Active  
Travel  
England

Your Ref: 25/01510/OUT  
Our Ref: ATE/25/00846/OUT  
Date: 30 June 2025

## Active Travel England Planning Response Detailed Response to an Application for Planning Permission

**Site Address:** LAND SOUTH OF PERDISWELL FARM, SHIPTON ROAD,  
SHIPTON ON CHERWELL, OX20 1GG

JOB TITLE		SOUTHEAST WOODSTOCK		CLIENT		BLENHIE PARTNERS	
DRAWING TITLE							
ACCESS STRATEGY OVERVIEW GENERAL ARRANGEMENT							
SCALE AT A0	DRAWN BY	DATE	DRAWING NO.	REVISION			
1:1000@A1	RM	03/12/25	23570-05-GA	E

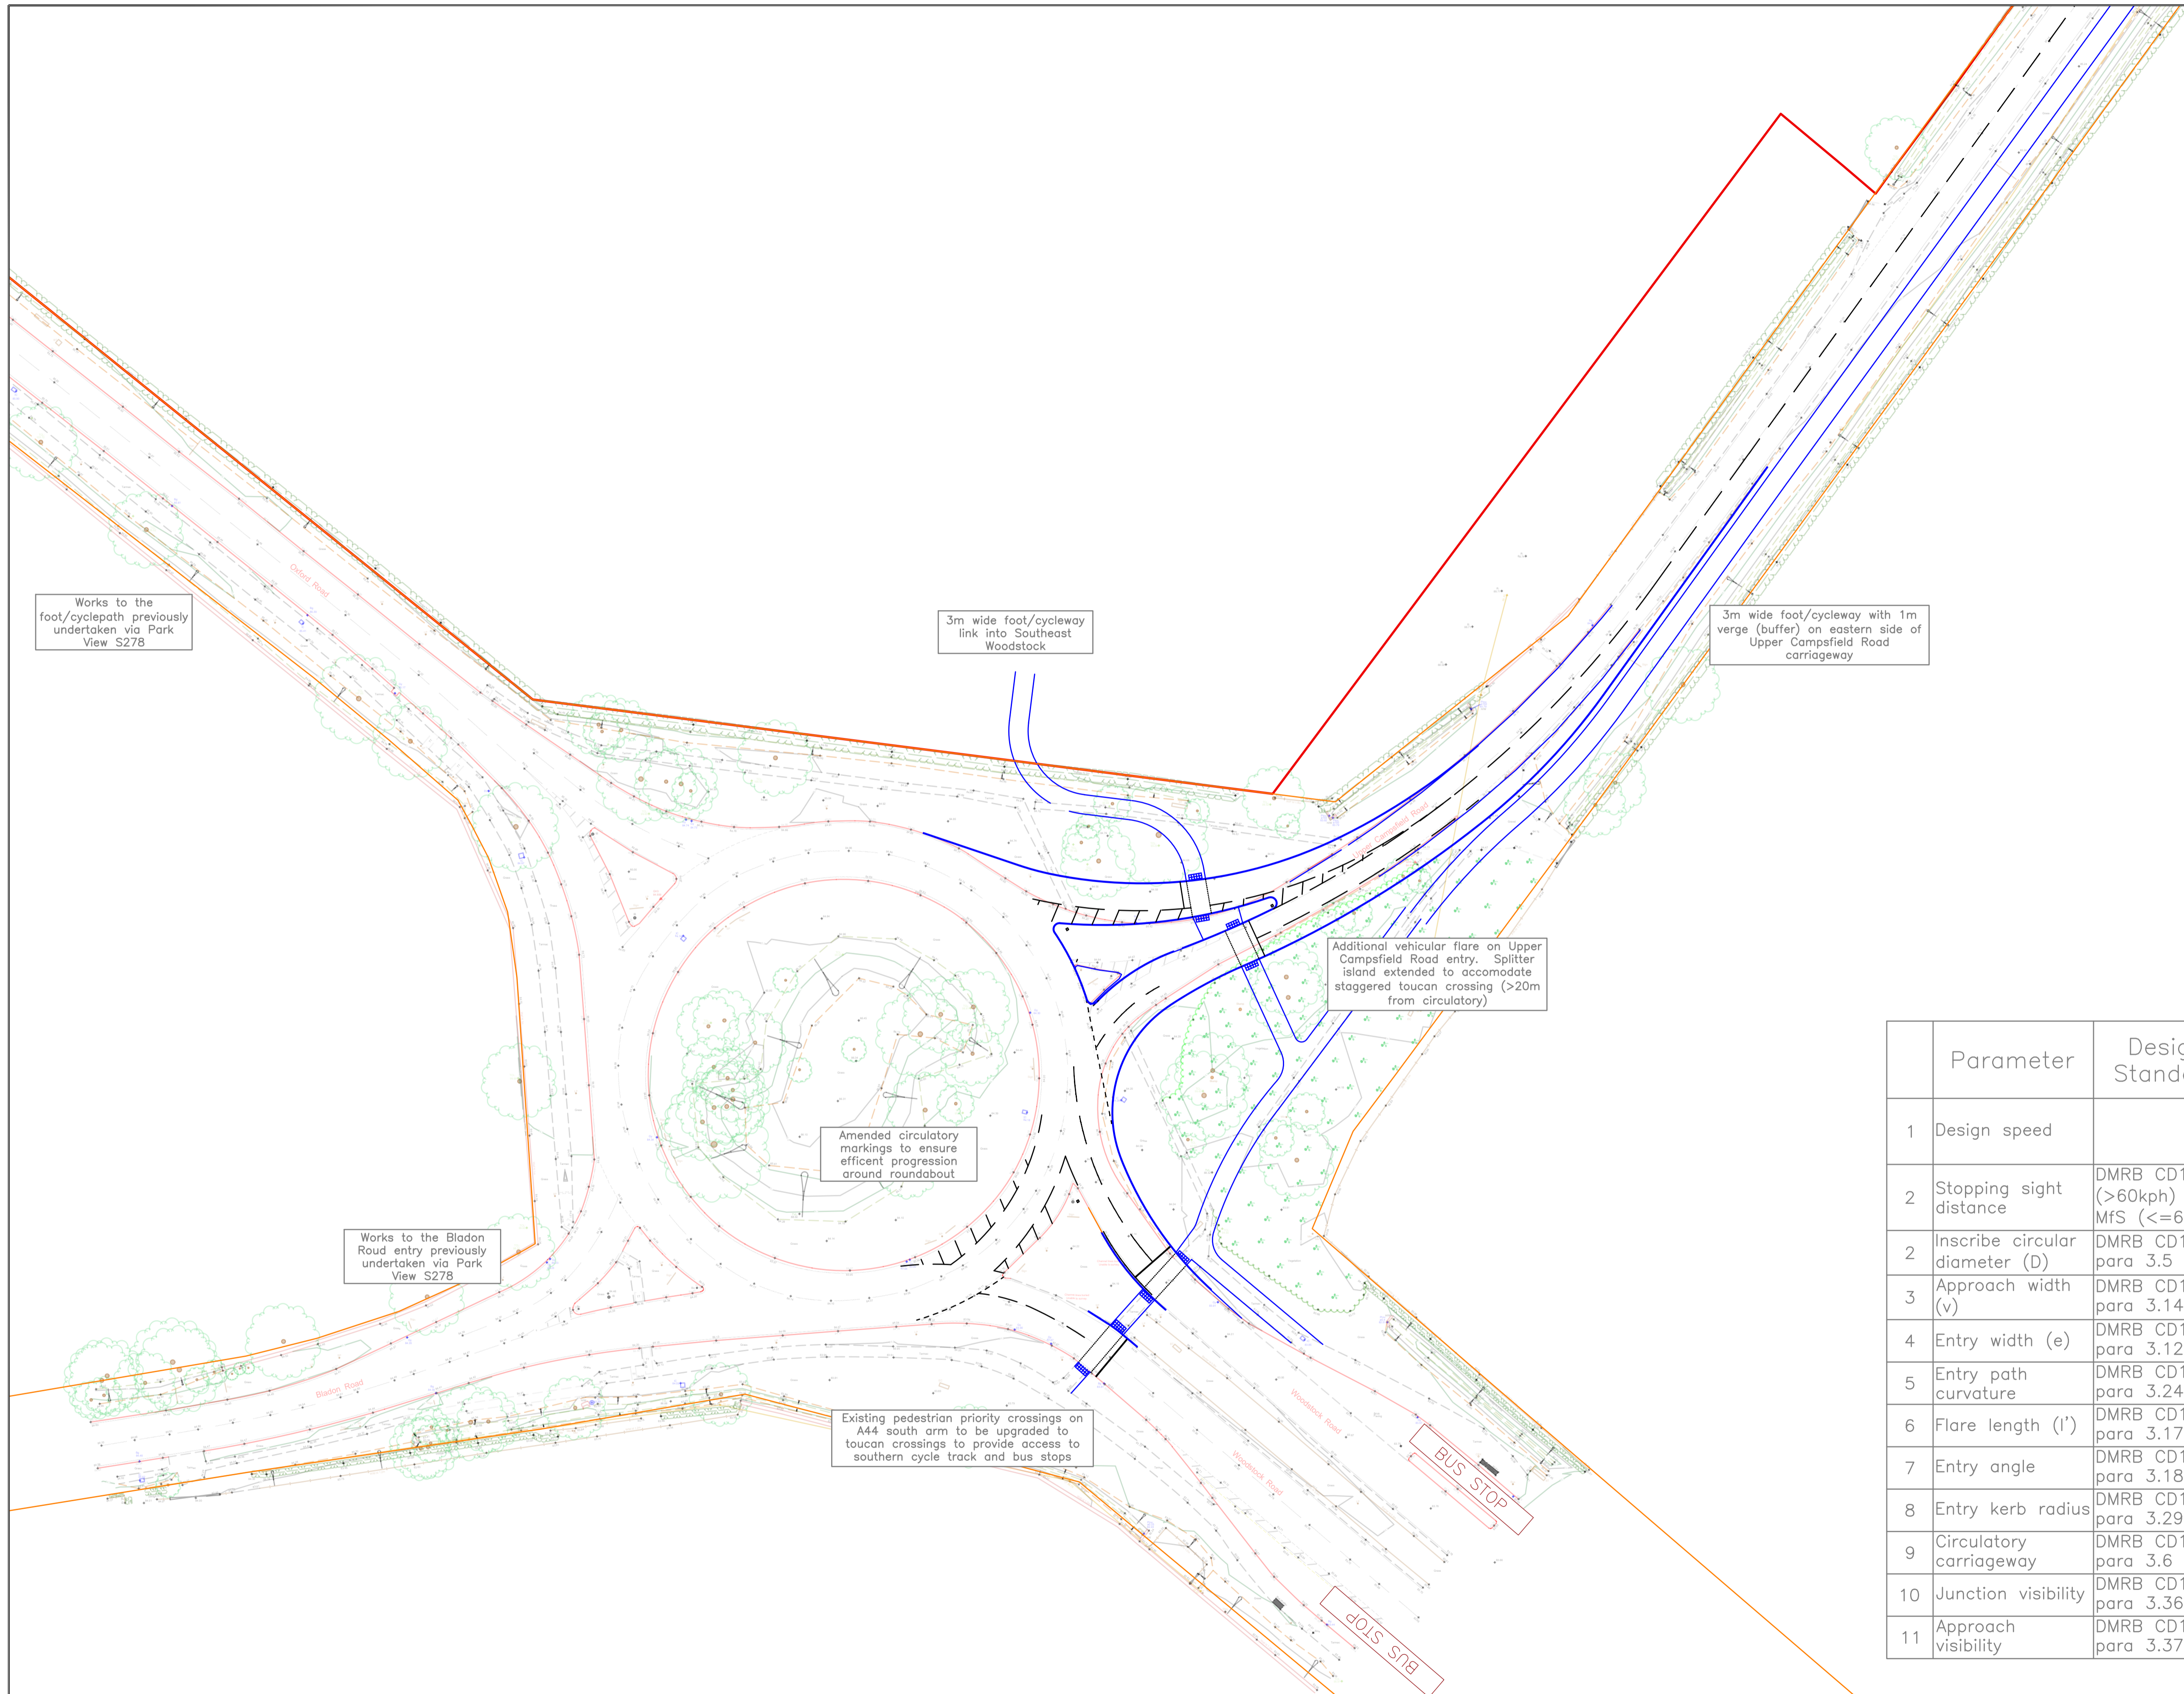
##### **Proposed Site Access (DTA Drawing 23570-05-GA)**

Paragraph 10.7.1 of LTN 1/20 notes that roundabouts account for approximately 20% of reported cyclist KSI (killed or seriously injured) casualties, with standard UK designs—particularly those with flared entries and exits—posing significant risks.

The proposed access roundabout appears to have been designed to DMRB standards, prioritising vehicle movement over active travel. LTN 1/20 states that roundabouts with flared geometry and no provision for cycling are unsuitable for most users and hazardous even for experienced cyclists.

The applicant should revise the design to align with LTN 1/20 principles, potentially including:

- Domed apex grass verges on all arms instead of easy-exit flares
- A central overrun area to narrow carriageway widths while maintaining HGV accessibility
- Single-lane entry and exit arms to reduce speeds

Consideration should also be given to creating a tapered transition from the highway to the shared-use facility for southbound cyclists along the A4095. This may require extending the facility northwards to allow cyclists to join it before the roundabout. A similar arrangement should be considered for northbound cyclists. An example can be seen via [this link](#).

JOB TITLE		SOUTHEAST WOODSTOCK		CLIENT		BLENHIEM PARTNERS	
DRAWING TITLE							
A44 BLADON ROUNDABOUT PROPOSED ACTIVE TRAVEL FOCUSED IMPROVEMENTS GENERAL ARRANGEMENT							
SCALE	DRAWN BY	DATE	DRAWING No	REVISION			
1:500@A1	RJM	03/12/25	23570-05-GA2	E

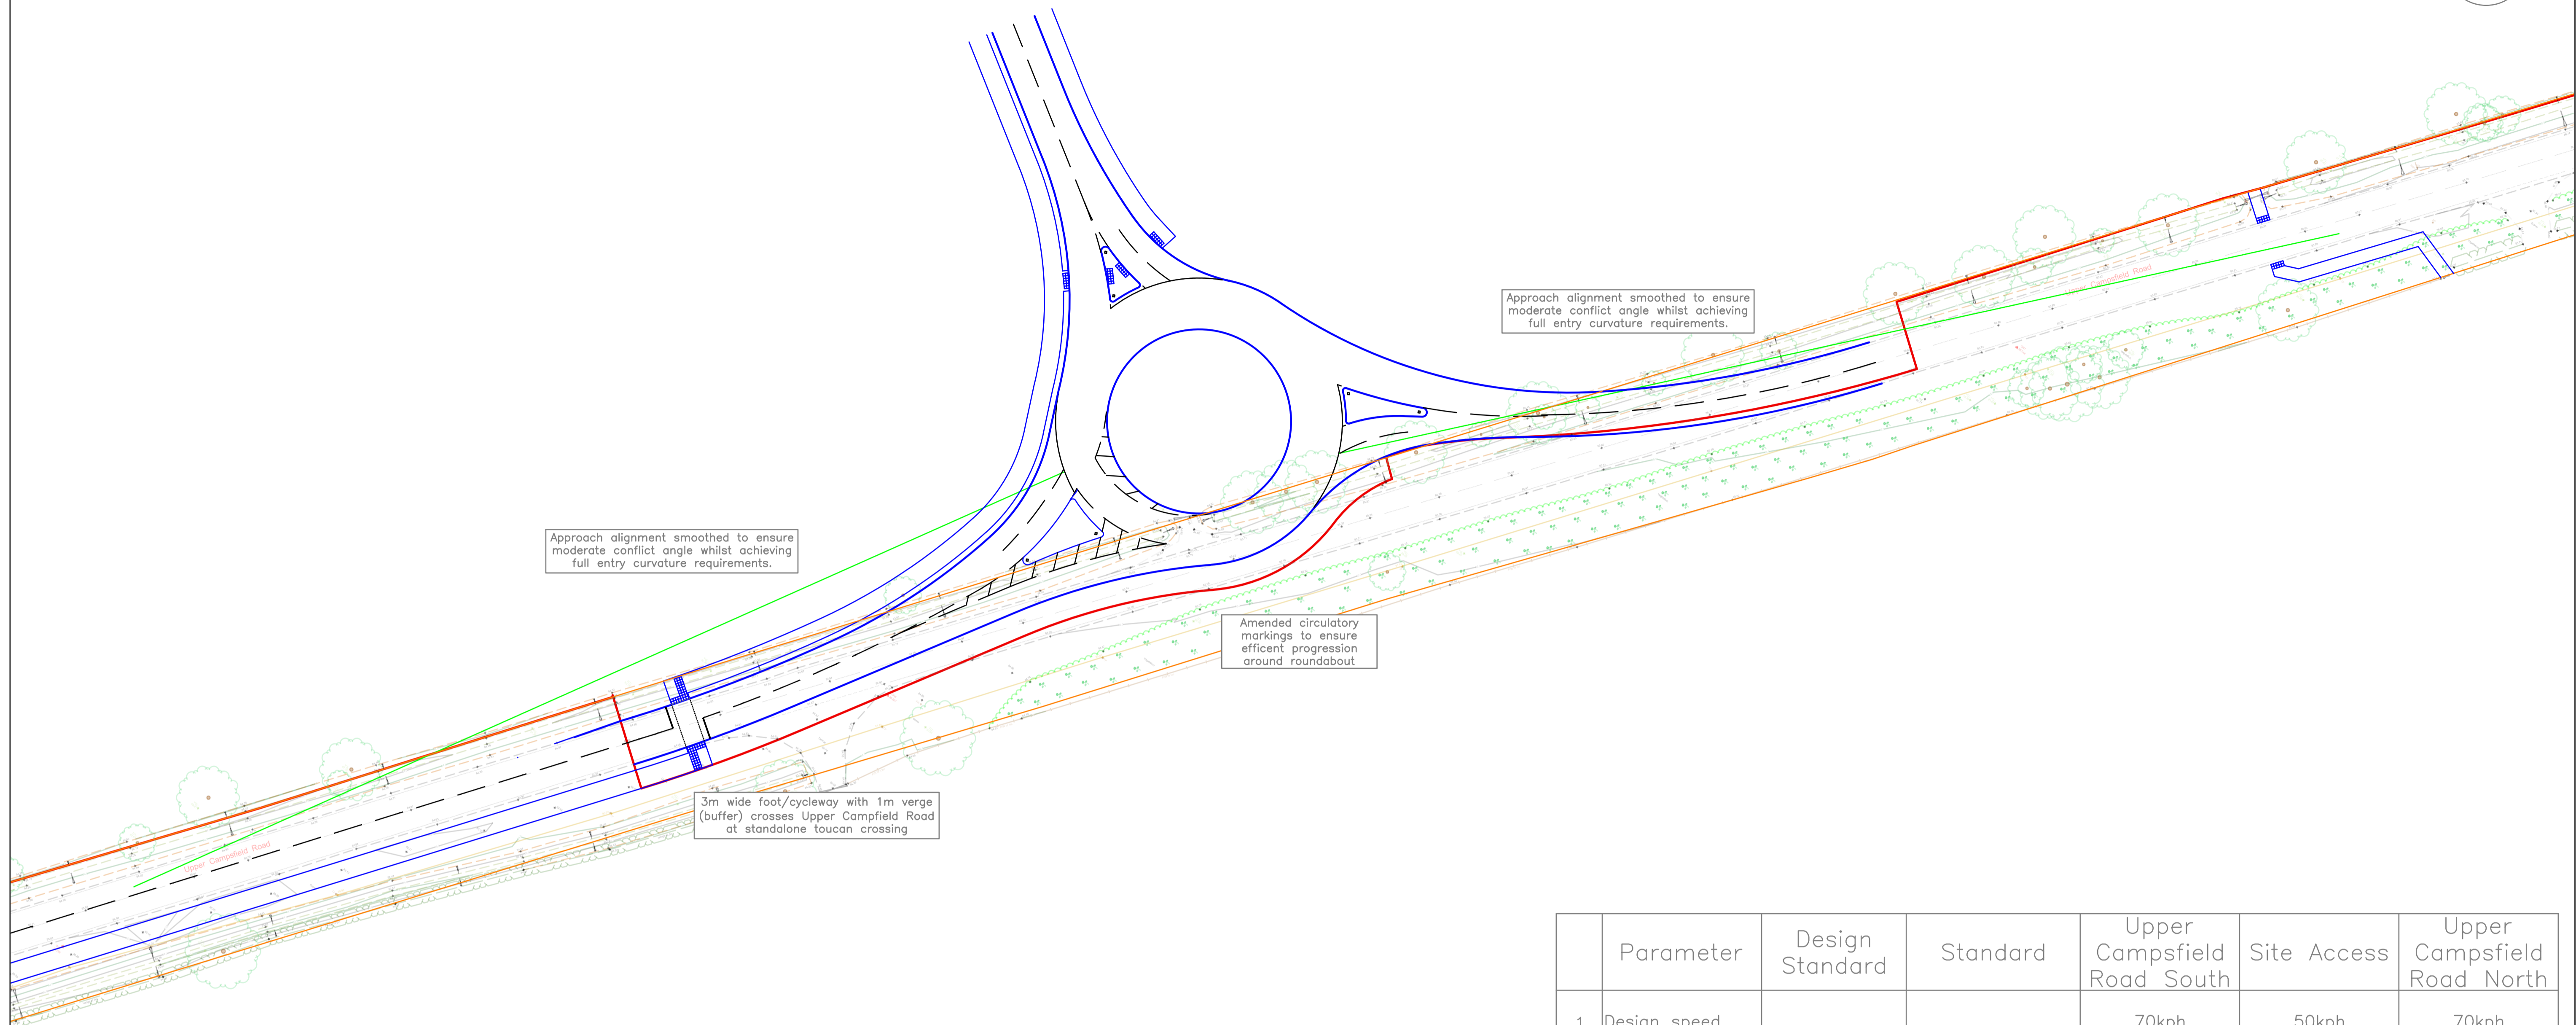
##### **Bladon Roundabout**

The applicant proposes several toucan crossings. It is assumed these will be signal-controlled; confirmation of this would be welcomed.

Clarification is also needed regarding whether upgrades have been undertaken—or are planned—on the route connecting the western and northern arms of the roundabout. If this connection forms part of the pedestrian and cycle network, improvements such as increased path width and enhanced surfacing should be provided to support coherence as outlined in LTN 1/20. The path/connection can be seen via [this link](#).

The toucan crossing on the A4095 would function more effectively as a direct, rather than staggered, crossing. It is also unclear whether the crossing is of sufficient width. Consideration should be given to increasing its width and height to accommodate a mix and volume of users.
